RE: 18th & Lomas Townhouse
Grading and drainage Plan
Engineer's Stamp Date 1-5-17 (File: J13D203)

CITY OF ALBUQUERQUE

RE: 18th & Lomas Townhouse
Grading and drainage Plan
Engineer's Stamp Date 11-18-16 (File: J13D203)

Drainage & Grading Plan

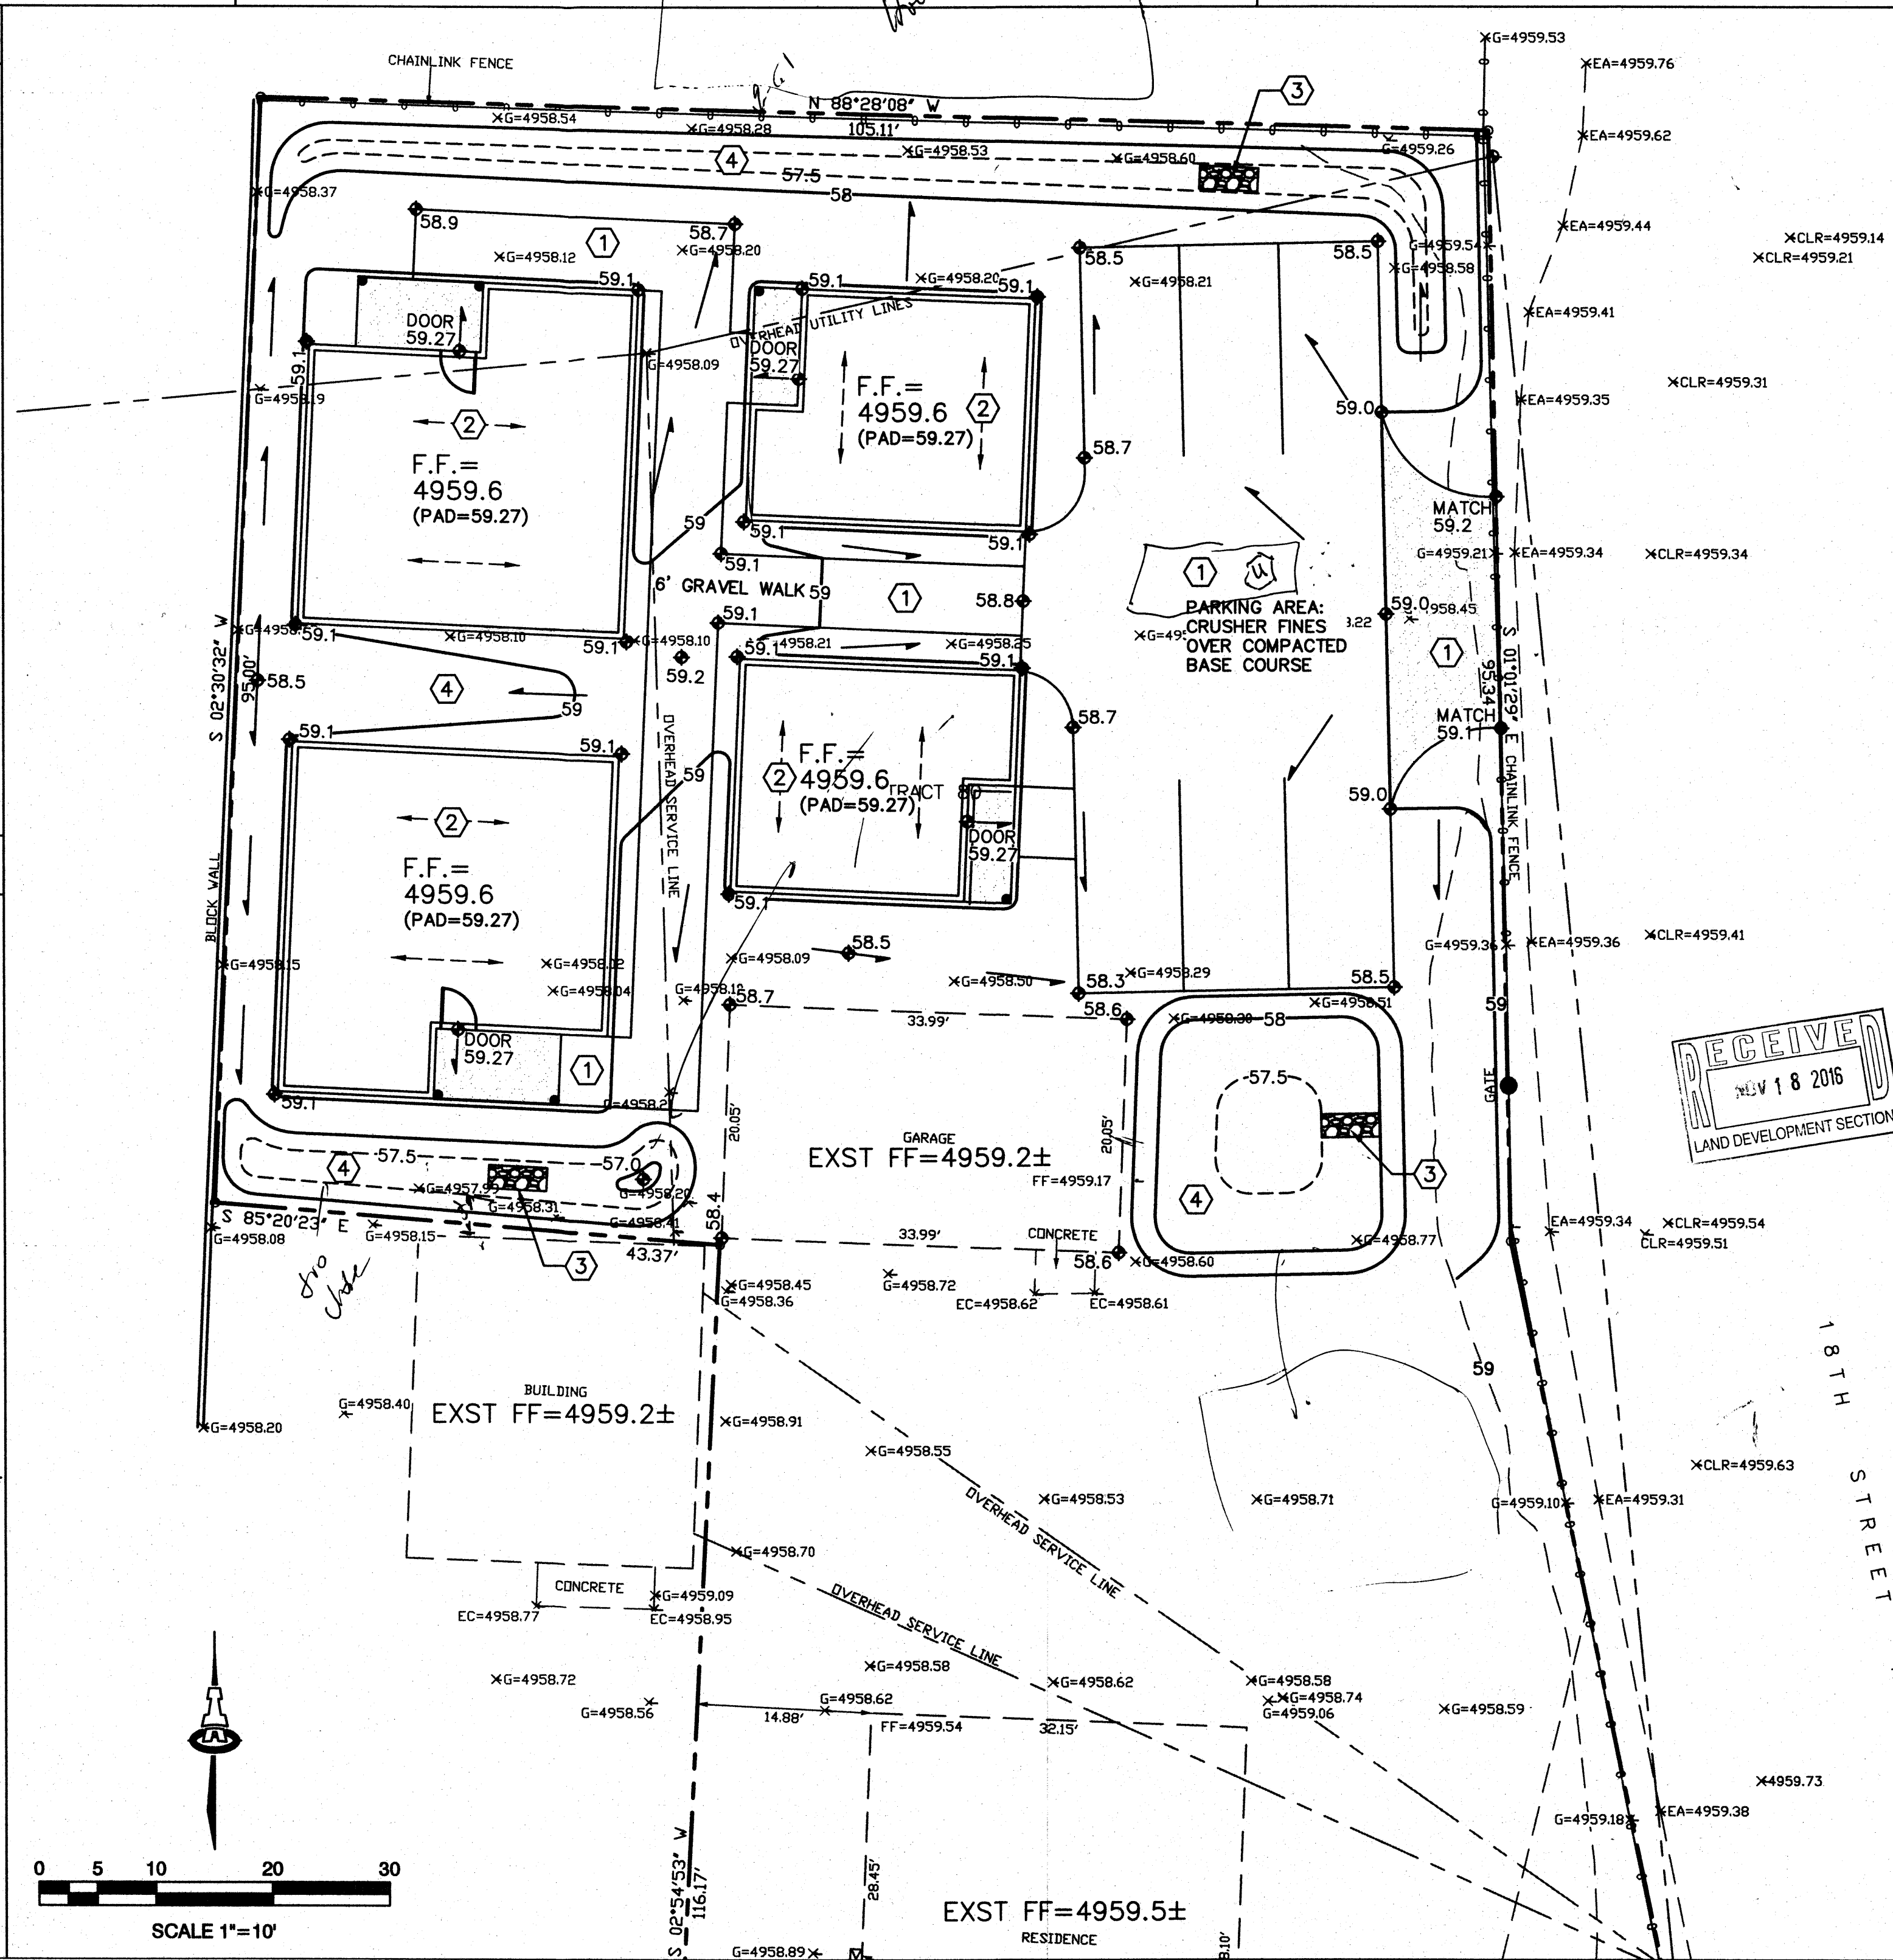
1. Are the ponds in the south west and in the north too close to existing structure?
Will they effect the foundation?
2. An infiltration system design should have the width or length dimensions, in plan view, greater than the depth dimension otherwise it is considered an injection well and a permit from the New Mexico Environment Department is required.
3. The infiltration system design should include a filter material to prevent fine material from entering the system.

1. The proposed ponding in this area is consistent with a flat grading concept with FF elevations raised approx. 1' above surrounding grades. The owner of the properties in the vicinity of the ponds (existing and proposed) understands the risks associated with a flat grading concept which includes shallow ponding adjacent to structures (see following page for signed disclaimer).
2. The percolation trench detail has been modified to ensure the length is greater than the depth dimension.
3. Per the original detail, the rock filled percolation trench is surrounded by a Geotex 501 non-woven geotextile fabric (top, bottom and sides).

TRAFFIC CIRCULATION LAYOUT PARKING AREA PLAN

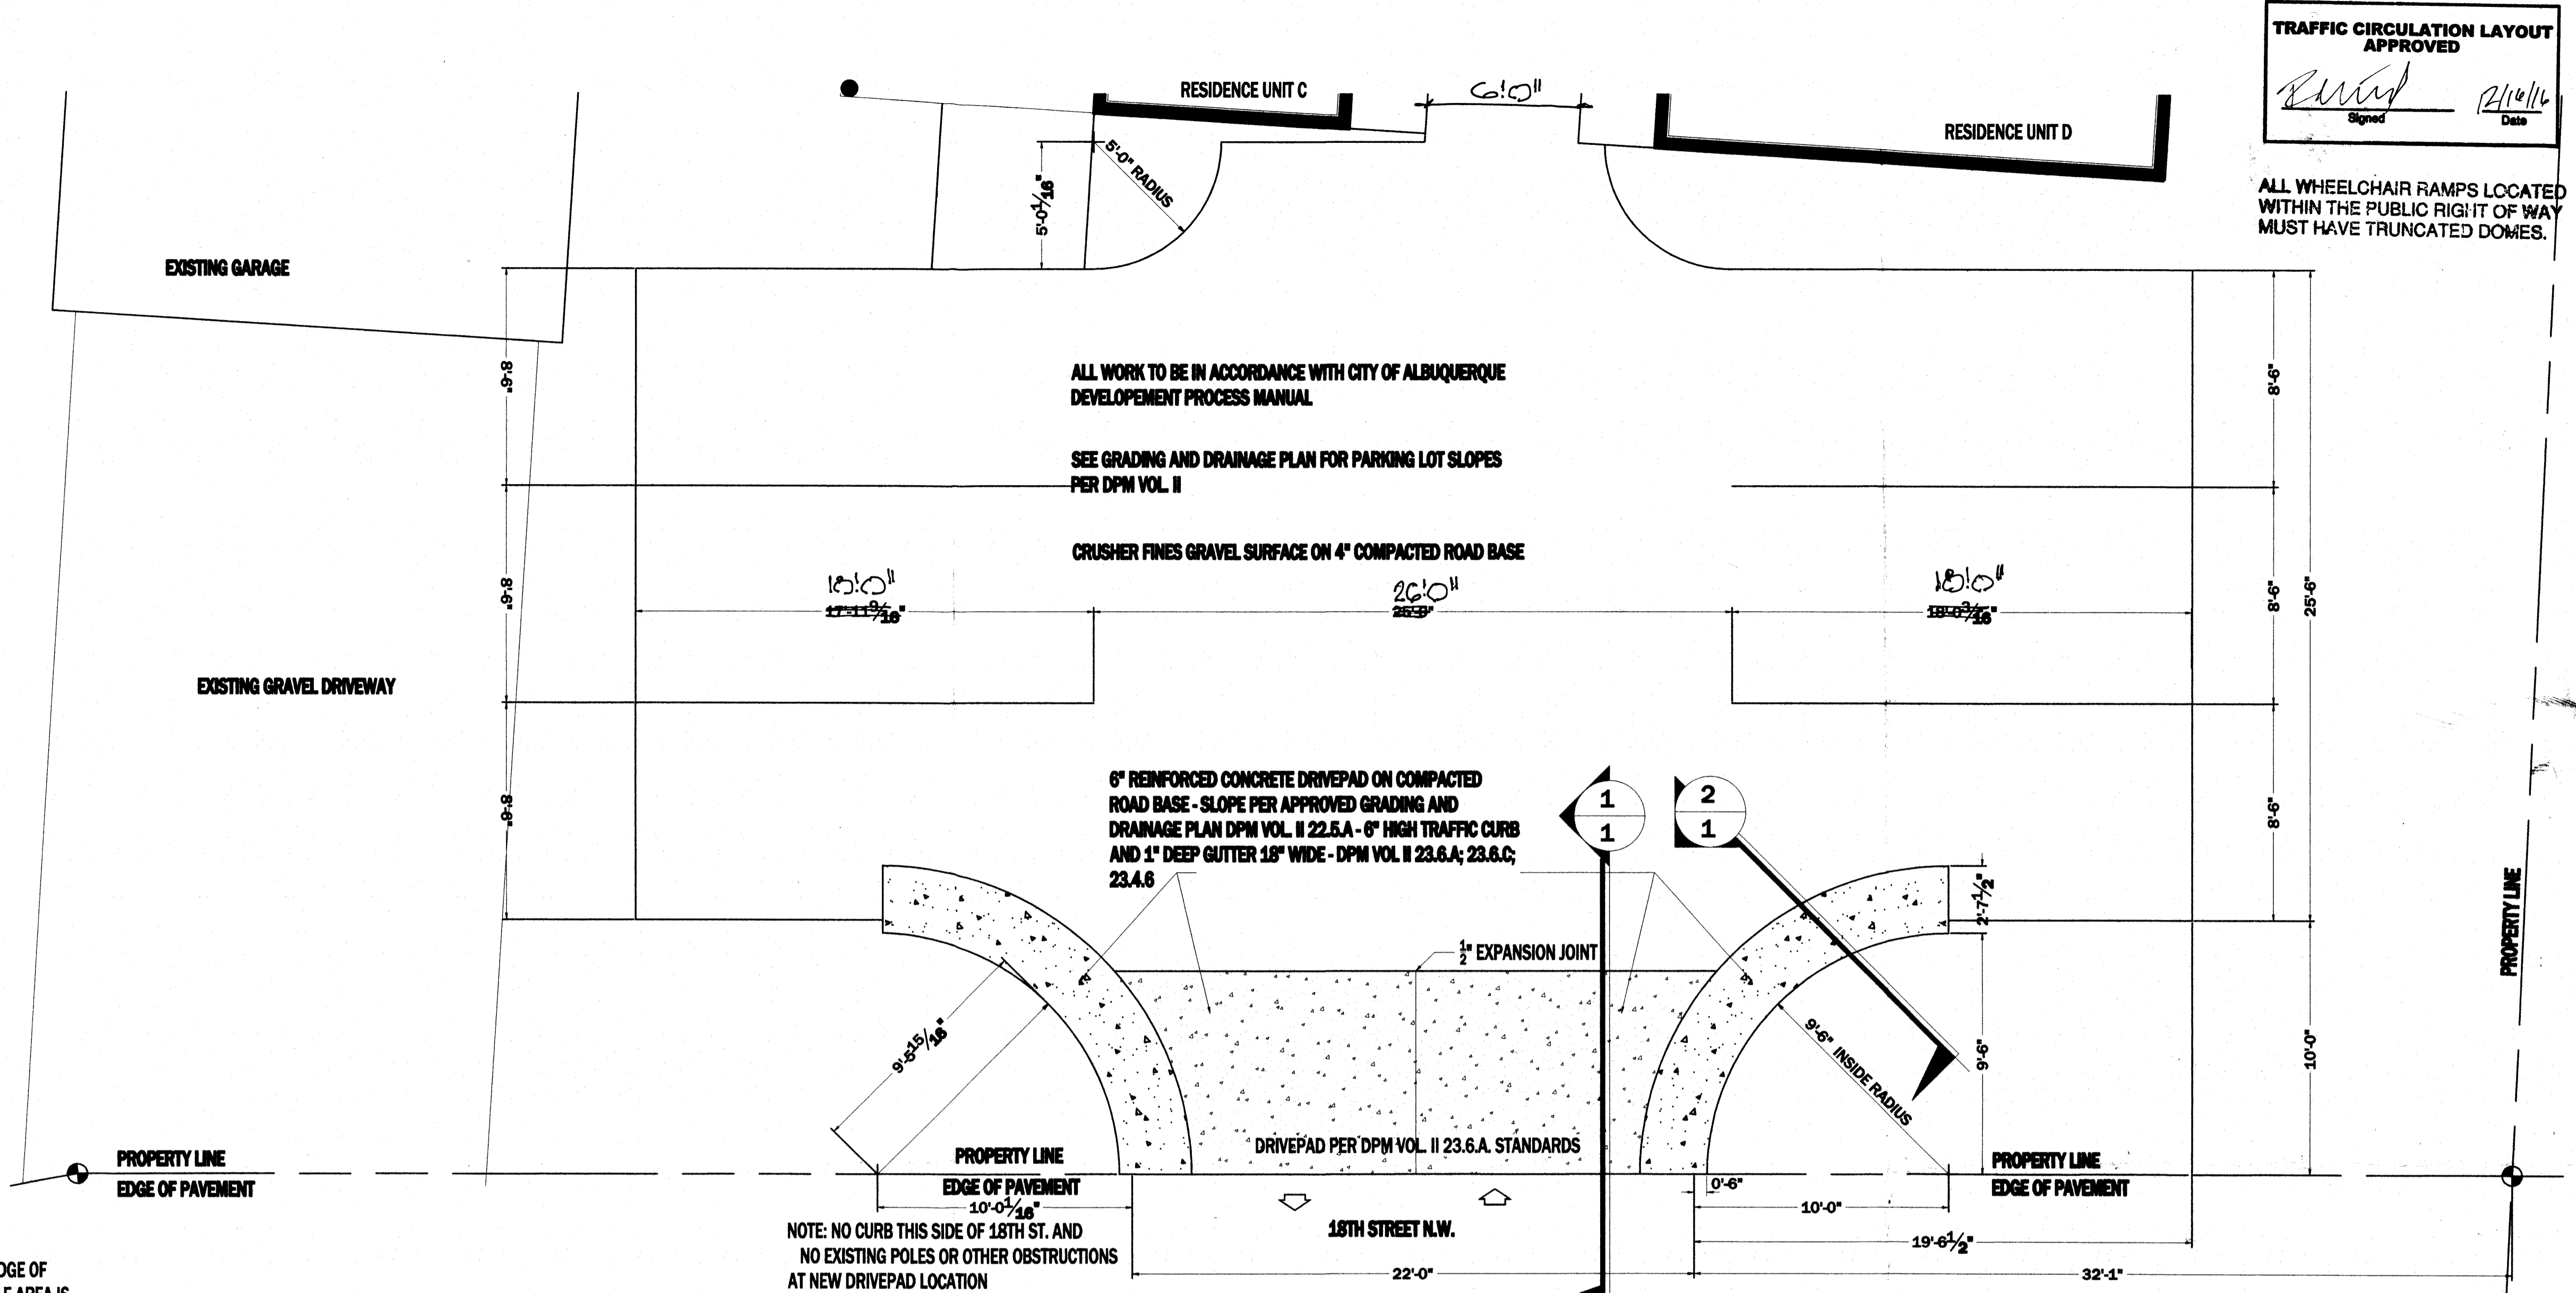
1. Please dimension the pedestrian path widths to the dwellings.
2. The dimensions on the plan and the detail are not matching up. Please clean up the dimensions.
3. Show the clear sight triangle and add the following note to the plan:
"Landscaping and signage will not interfere with clear sight requirements. Therefore, signs, walls, trees, and shrubbery between 3 and 8 feet tall (as measured from the gutter pan) will not be acceptable in the clear sight triangle.
